Subject: FW: N of Summer Lane P/35/20/DOC & P/37/20/DOC

Subject: N of Summer Lane P/35/20/DOC & P/37/20/DOC

We have the following comments regarding the revised surface water drainage details submitted for P/35/20/DOC and P/37/DOC.

Headwall SW-13

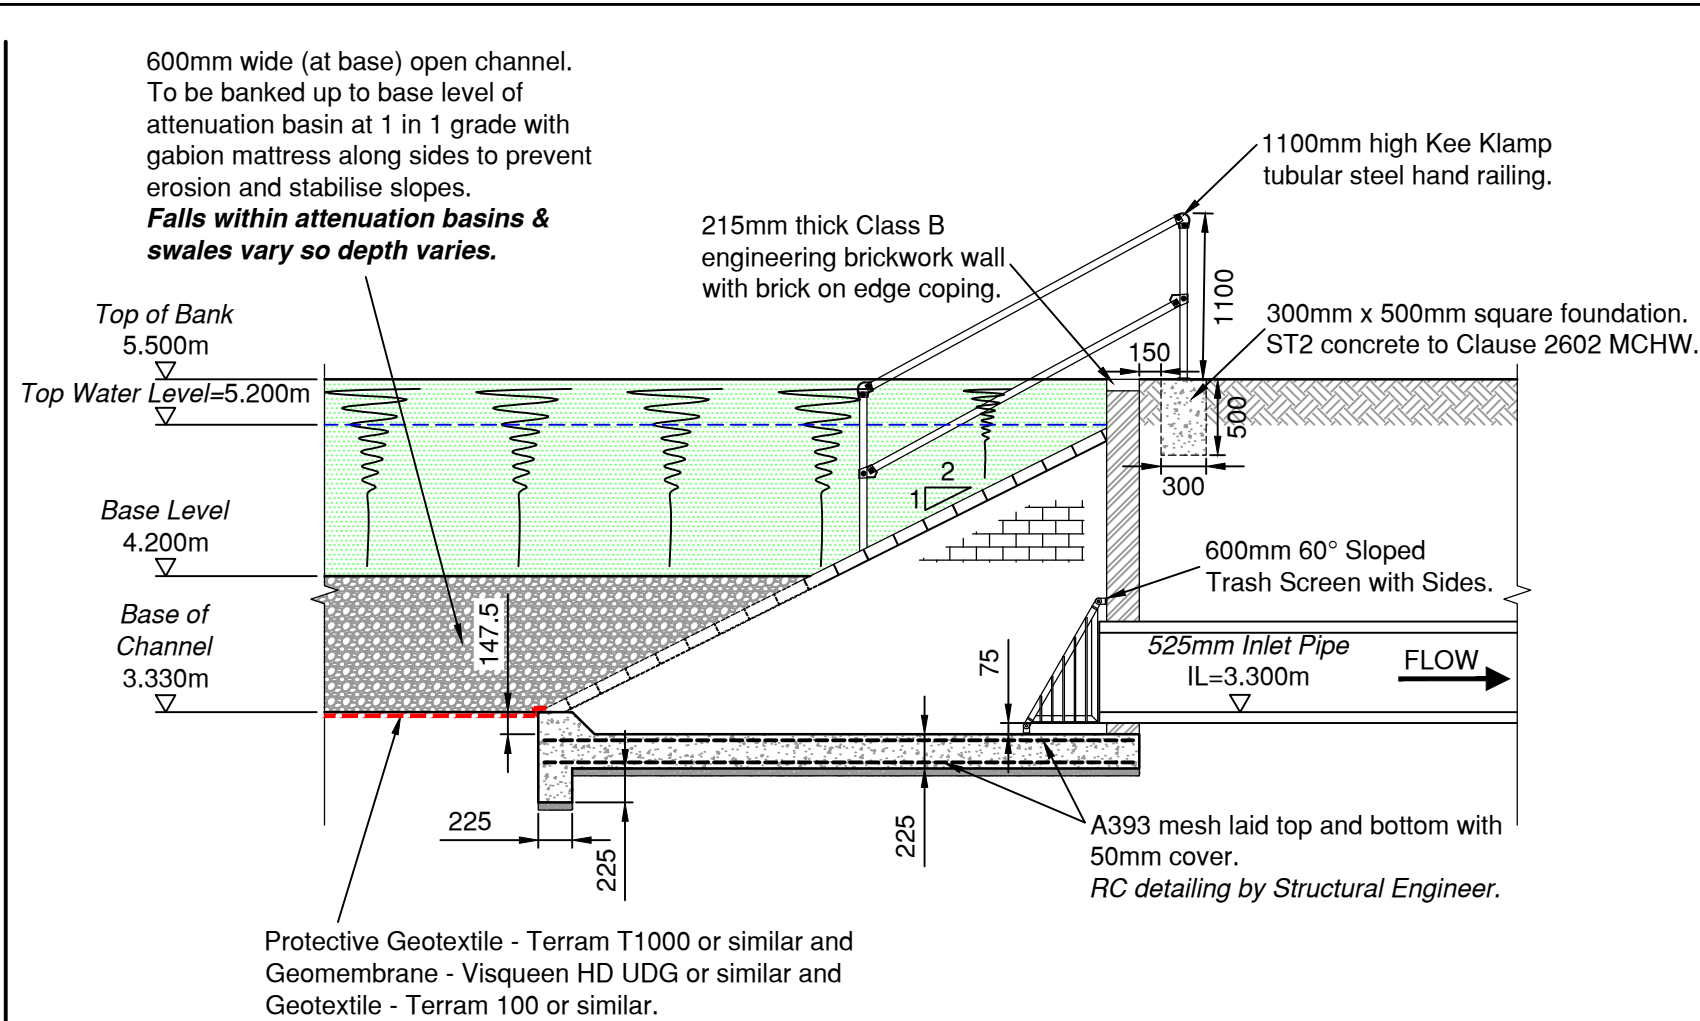
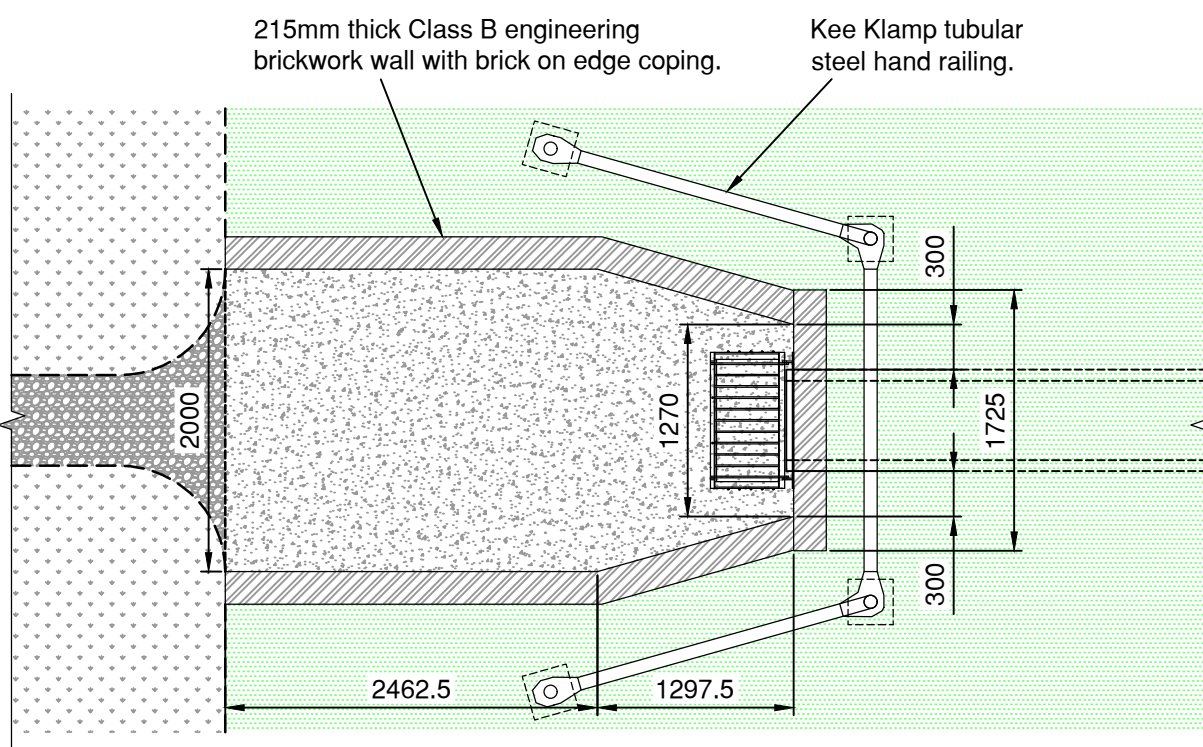
9. All headwall grilles to be cranked as opposed to be flat or just sloped faced. Headwalls SW-4, SW-5, SW-9, SW-13, SW-29 and SW-32 updated to cranked grilles. Headwall SW-9 cross-section grille not shown (layer not visible?), please ensure this is visible on drawings. Please remove note to Sewers for Adoption, please add construction detail showing typical grille, ensuring that bar spacing, materials, point of lock are shown.

Headwall SW-32

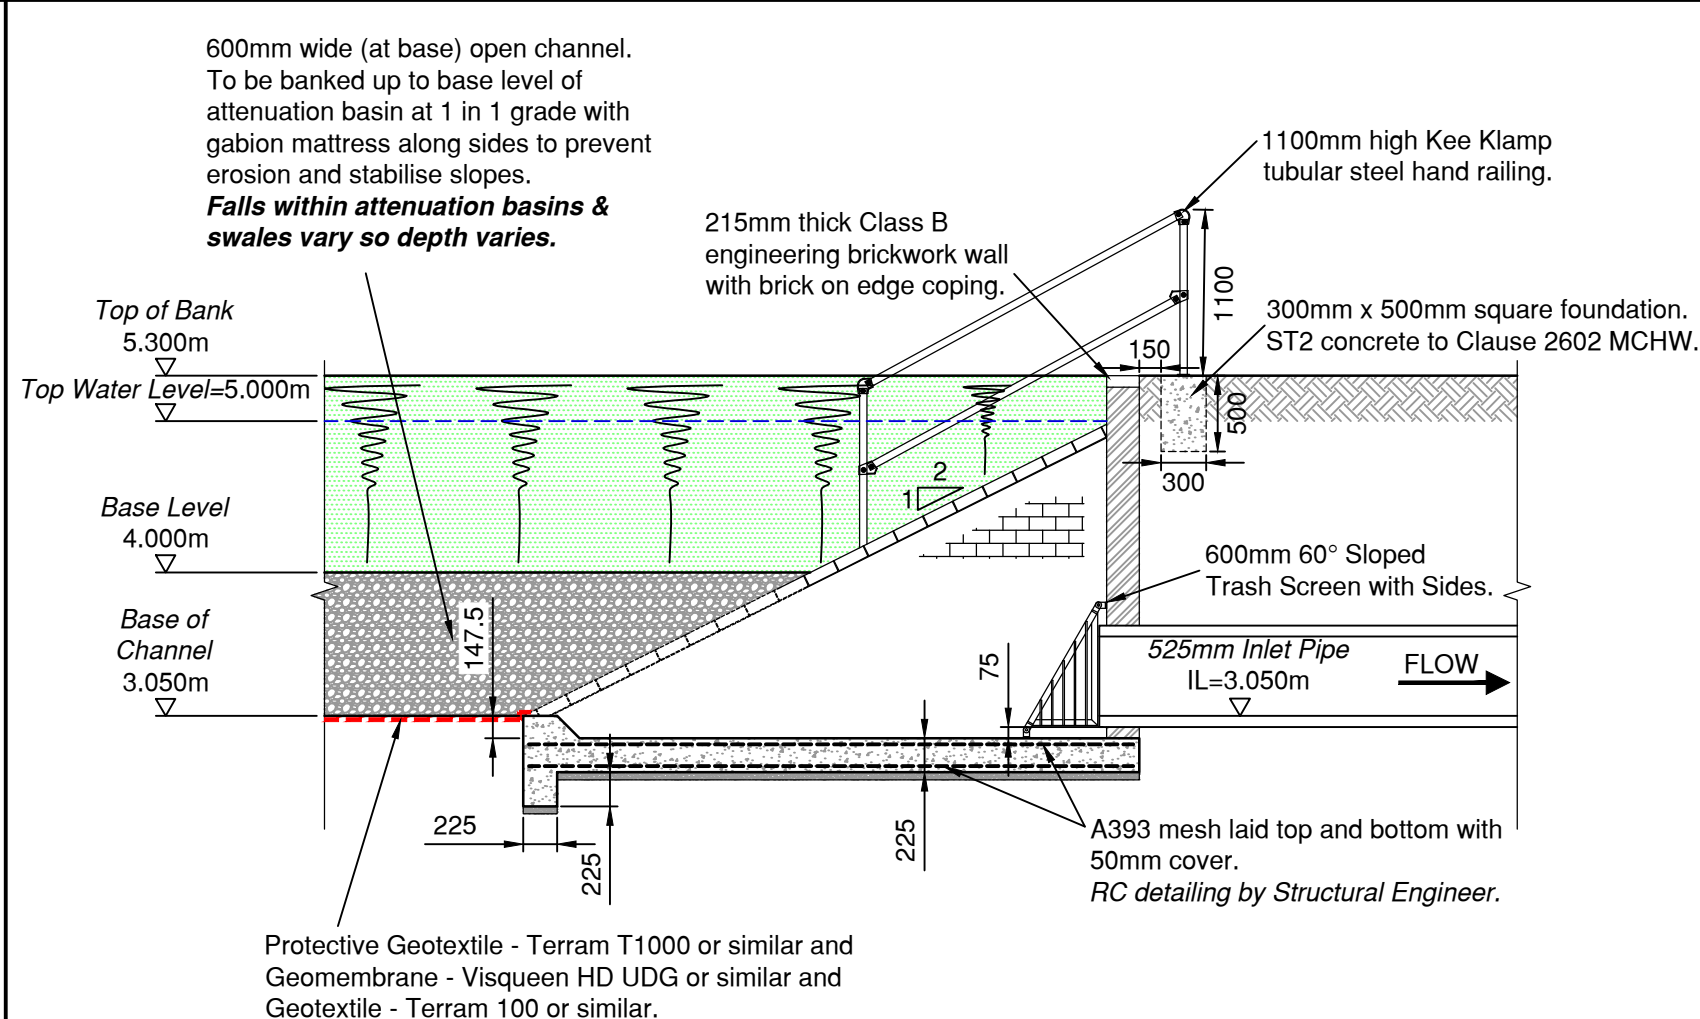
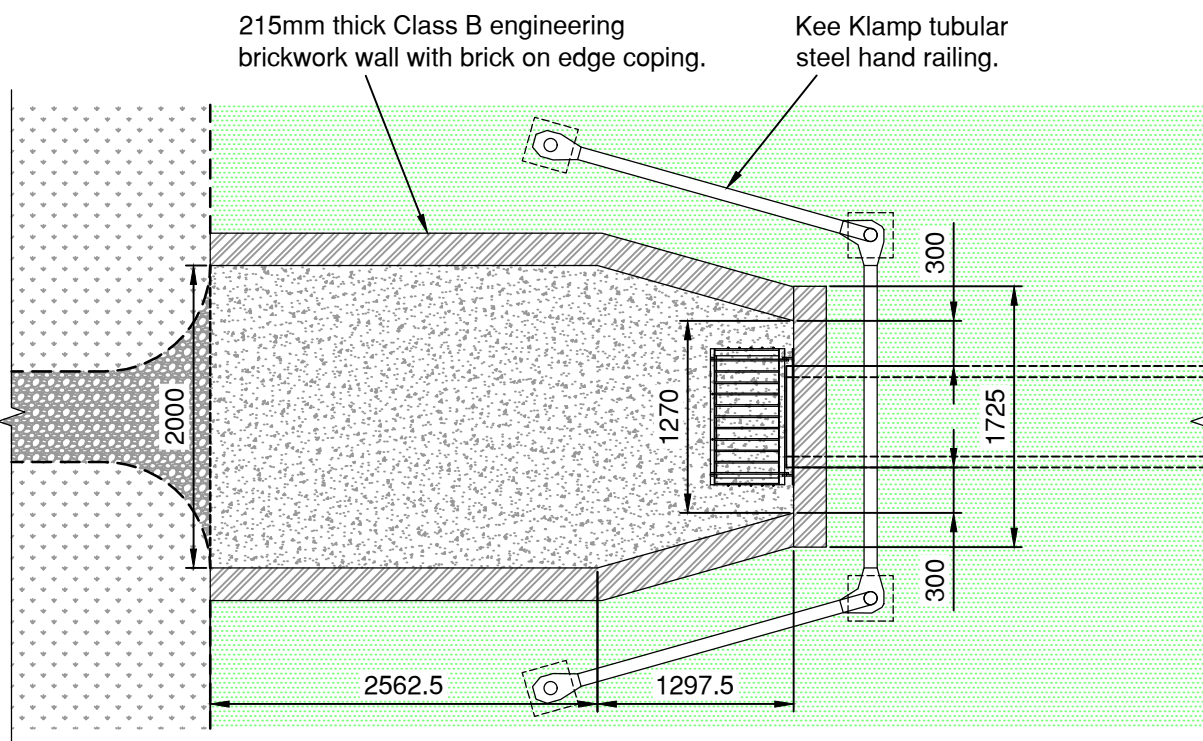
17. Incoming pipes at headwalls SW-4, SW-5 and SW-32 – increase freeboard between pipe inverts and basin/swale bed. The base of the pipe work connects to the drain bed level, which is specifically deepened to accommodate the incoming pipework levels and eventually connect onto the downstream watercourse. This is a similar arrangement to the main drainage channel running through the swale associated with headwalls SW9 and Sw13. *Understand the difficulties here, however minimum of 150mm above pipe inverts and base of swale should be provided.*

44. Headwall SW-32 – investigate connecting the 450mm and 225mm pipes together via a manhole before connection to the headwall or alter upstream arrangement to ensure both pipes connect to headwall in parallel. – Already actioned as part of subsequent update

Headwall SW-14

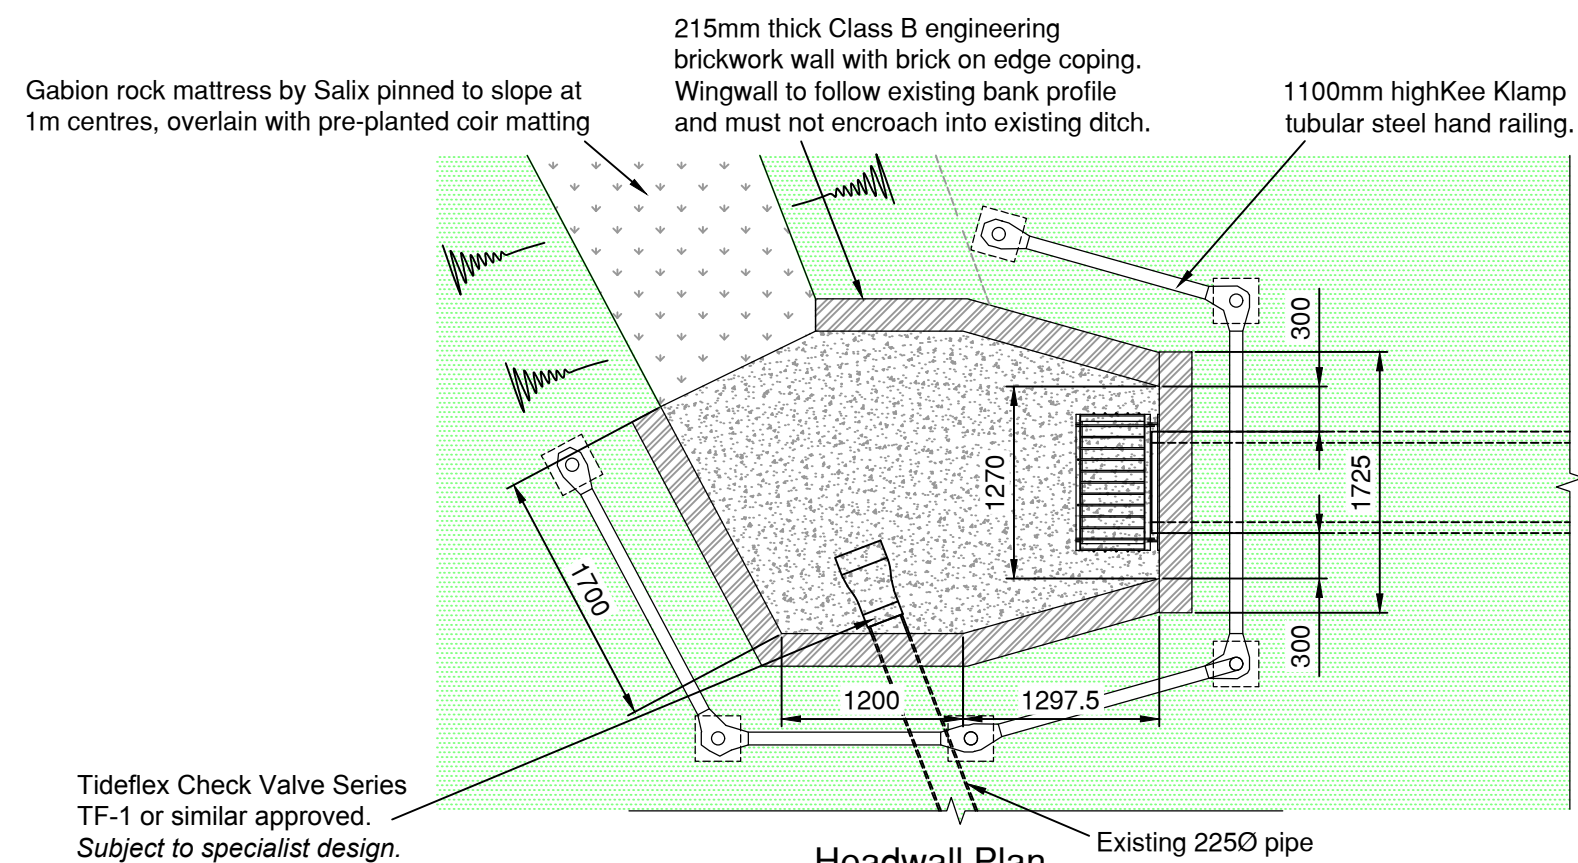
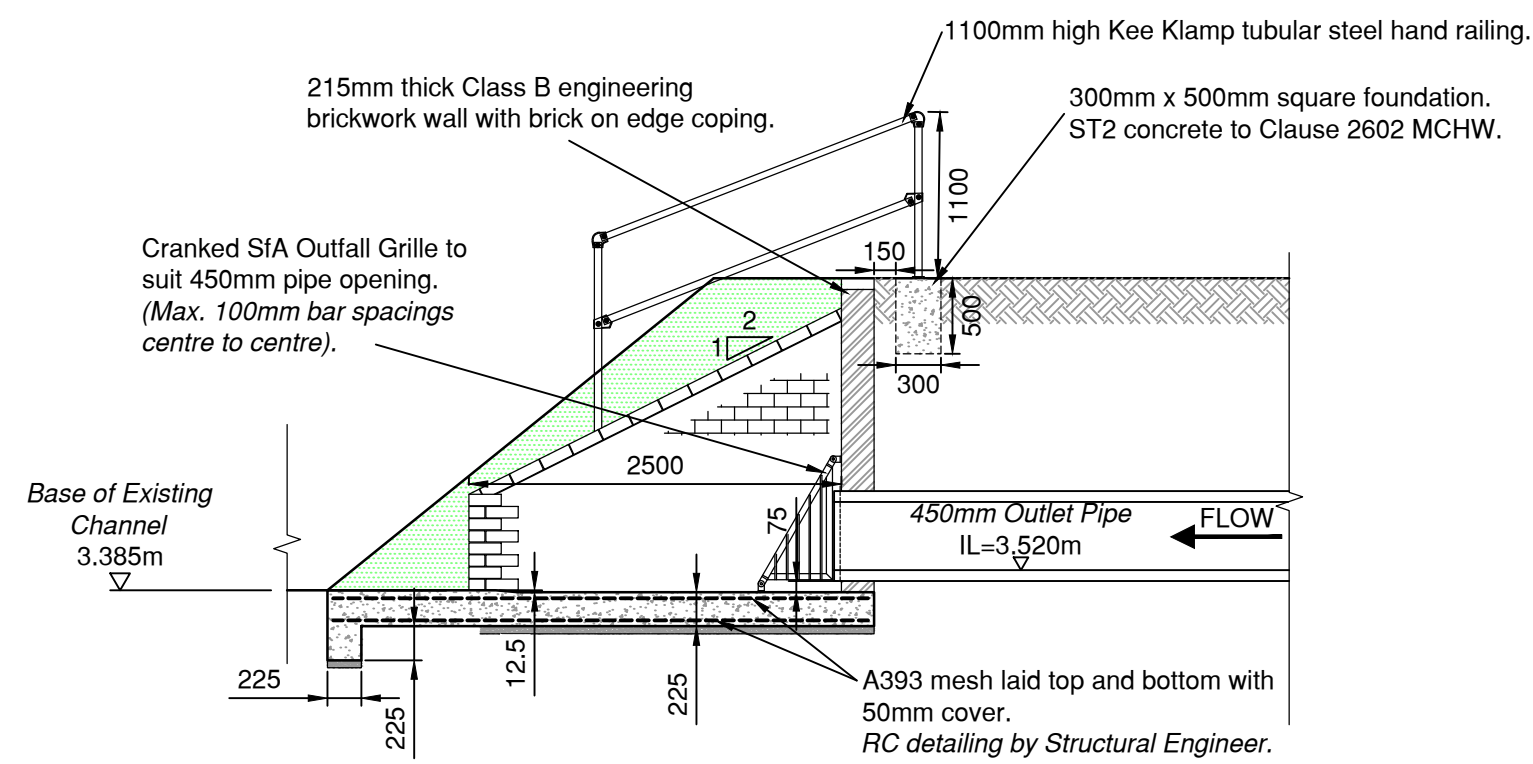
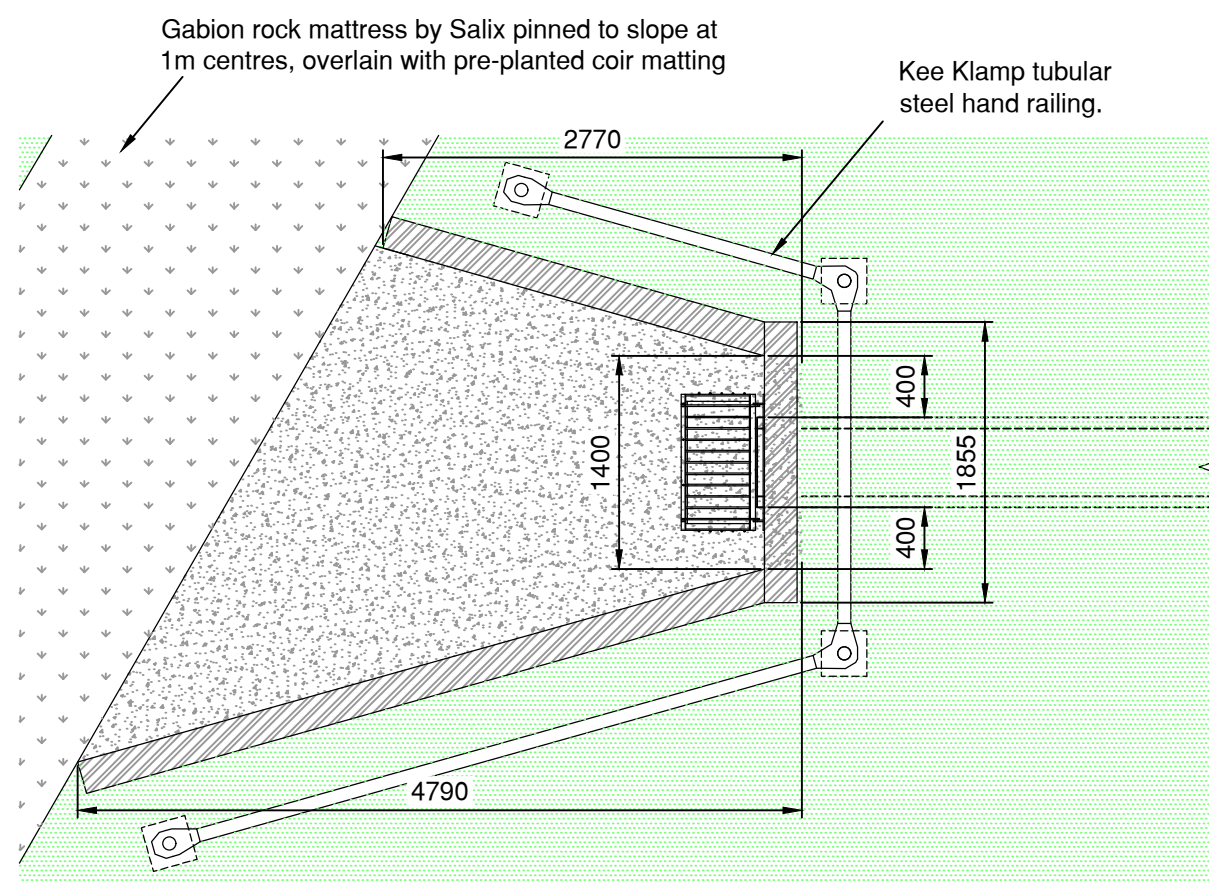
10. Provide construction detail for headwall SW-14. Per OWC – will be provide a copy of these along with this response as well. Unclear where this is included in details, please provide.
